**Consultation Response from KC,
Highways Development Management****2026/91664 adj, 5, Fernside Avenue, Almondbury, Huddersfield, HD5 8NR****Demolition of existing building and erection of dwelling****Date Responded: 21/07/2026****Responding Officer: D. Stainsby****Responding Ref: K6-15NW/23**

This application is for the Demolition of an existing builders' store/depot and erection of a dwelling.

PROPOSED SITE PLAN
1:200

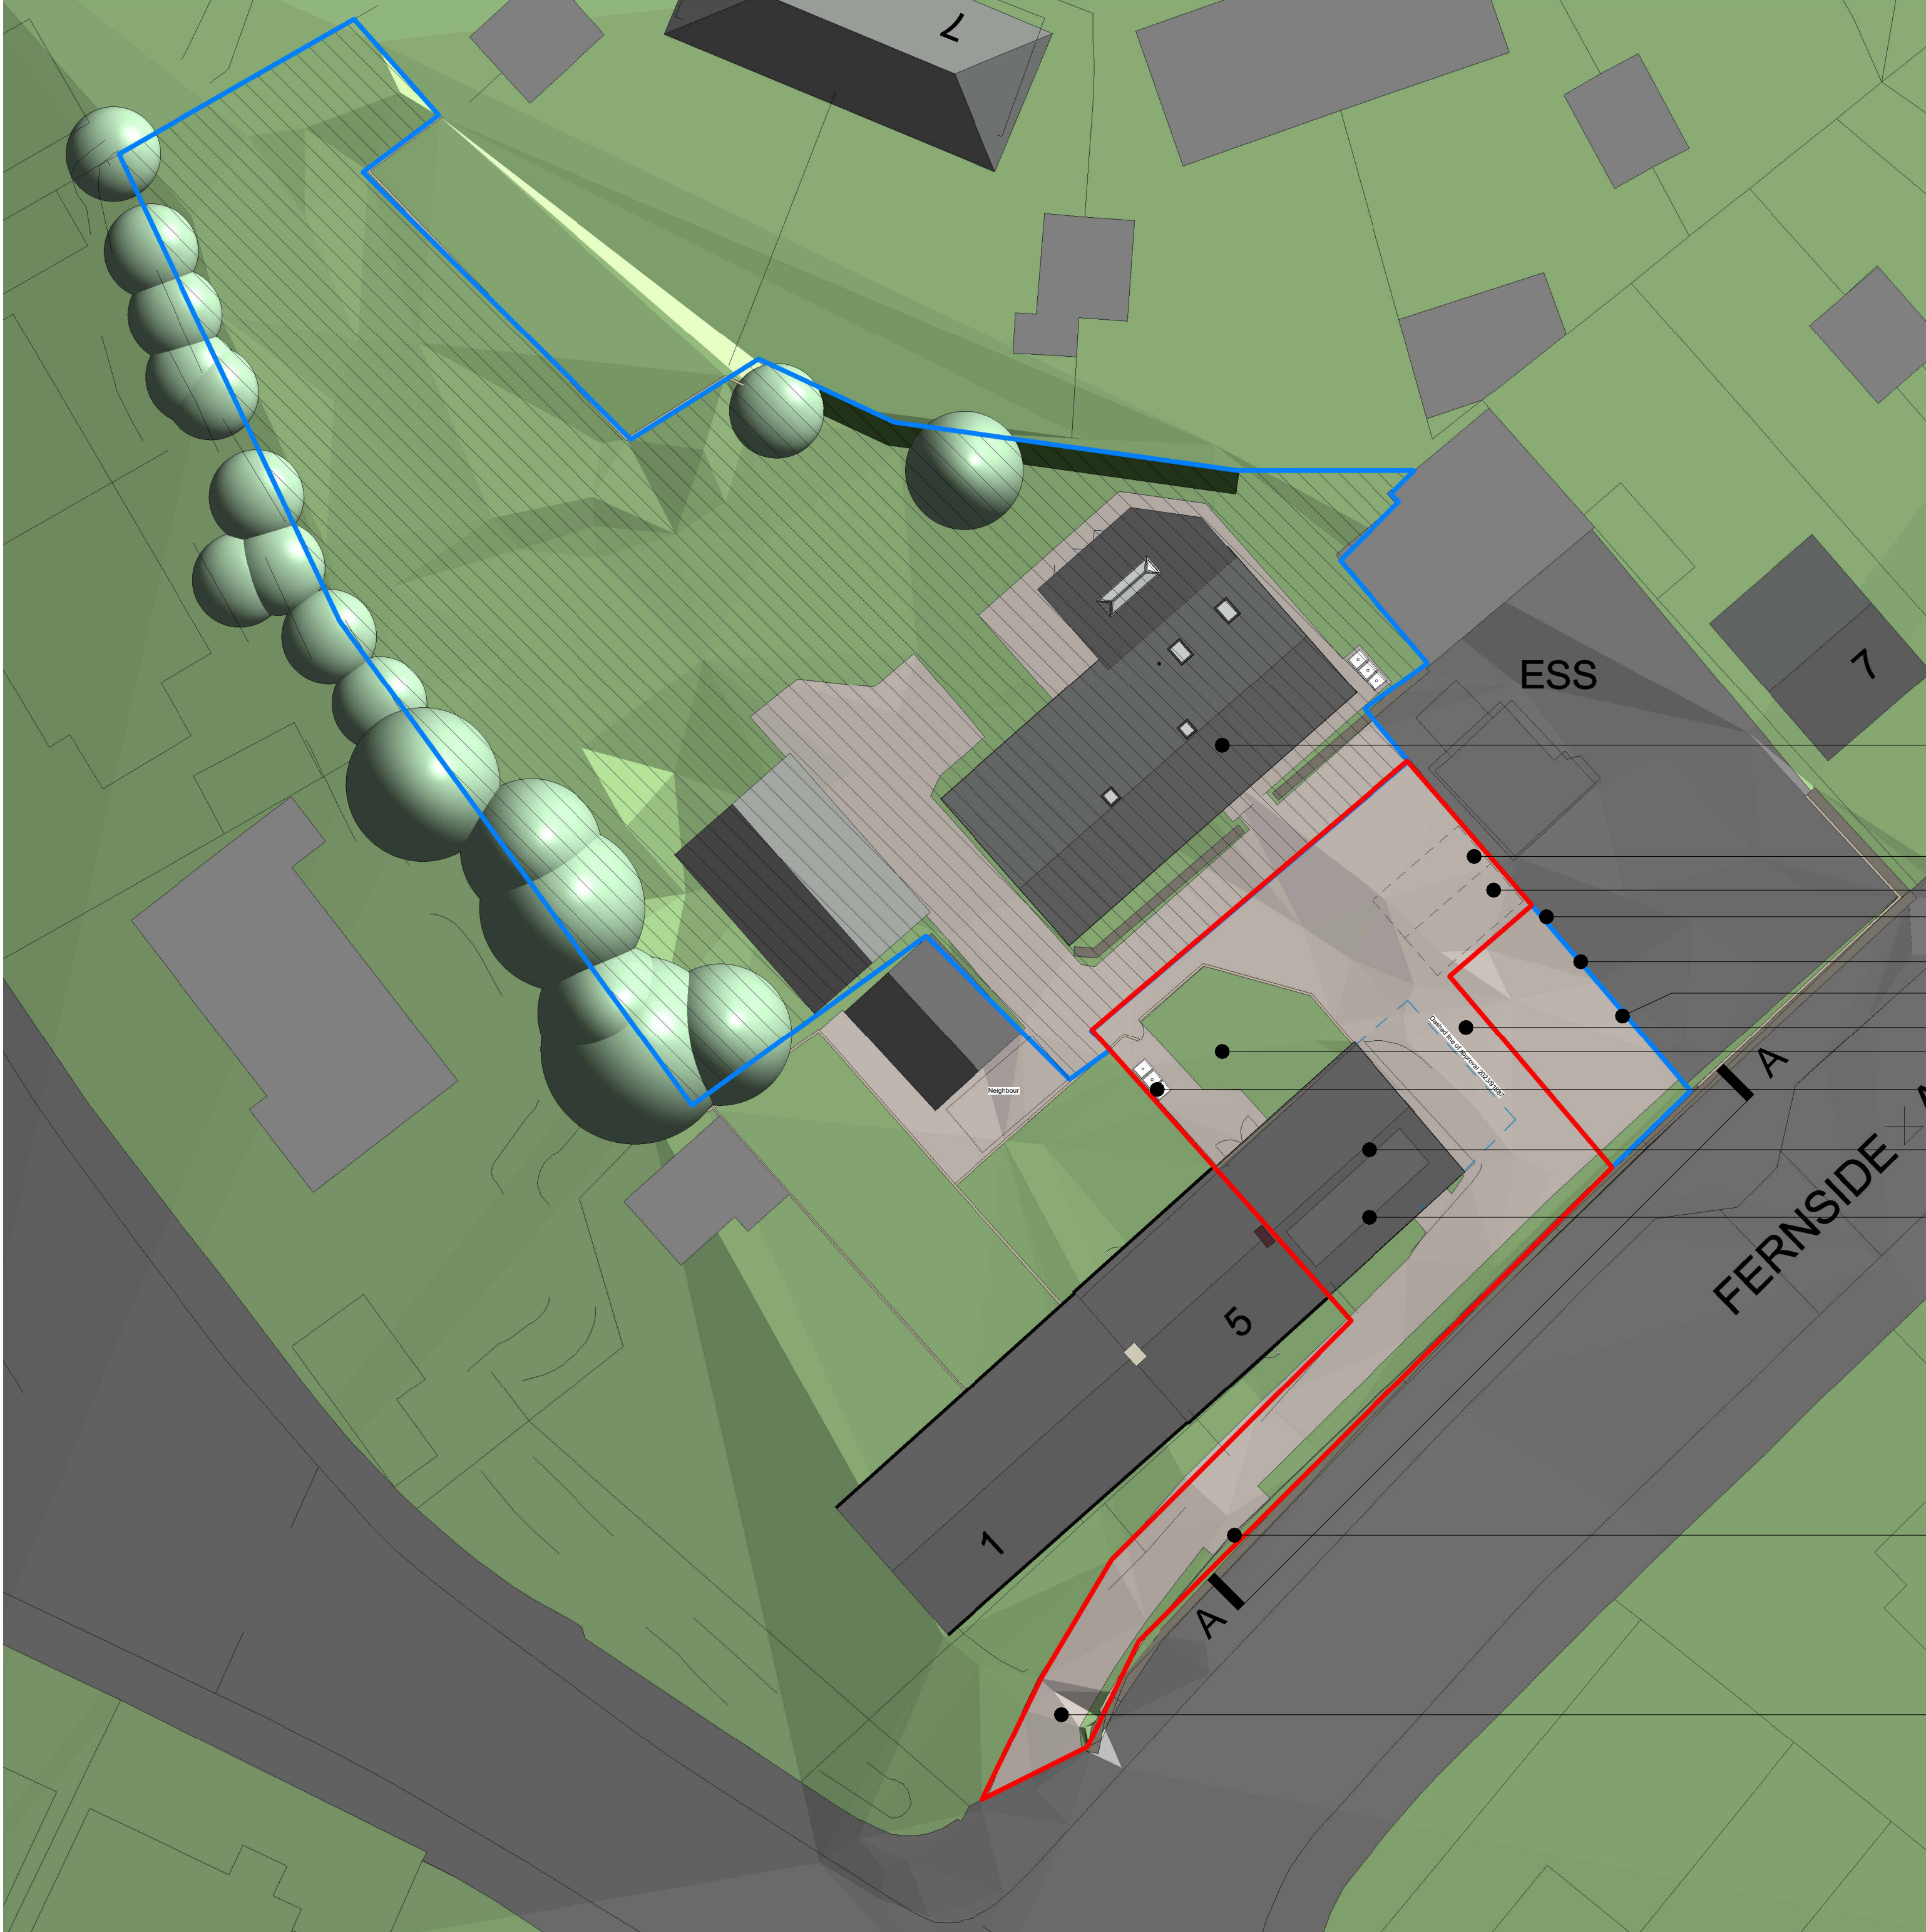
This proposal is for one dwelling with two parking spaces and will, therefore, generate a lower parking demand and fewer vehicle movements than the previous approval

The approved vehicle parking areas will need to be surfaced and drained in accordance with the Communities and Local Government; and Environment Agencies 'Guidance on the permeable surfacing of front gardens (parking areas)' published 13th May 2009 (ISBN 9781409804864) as amended or superseded.
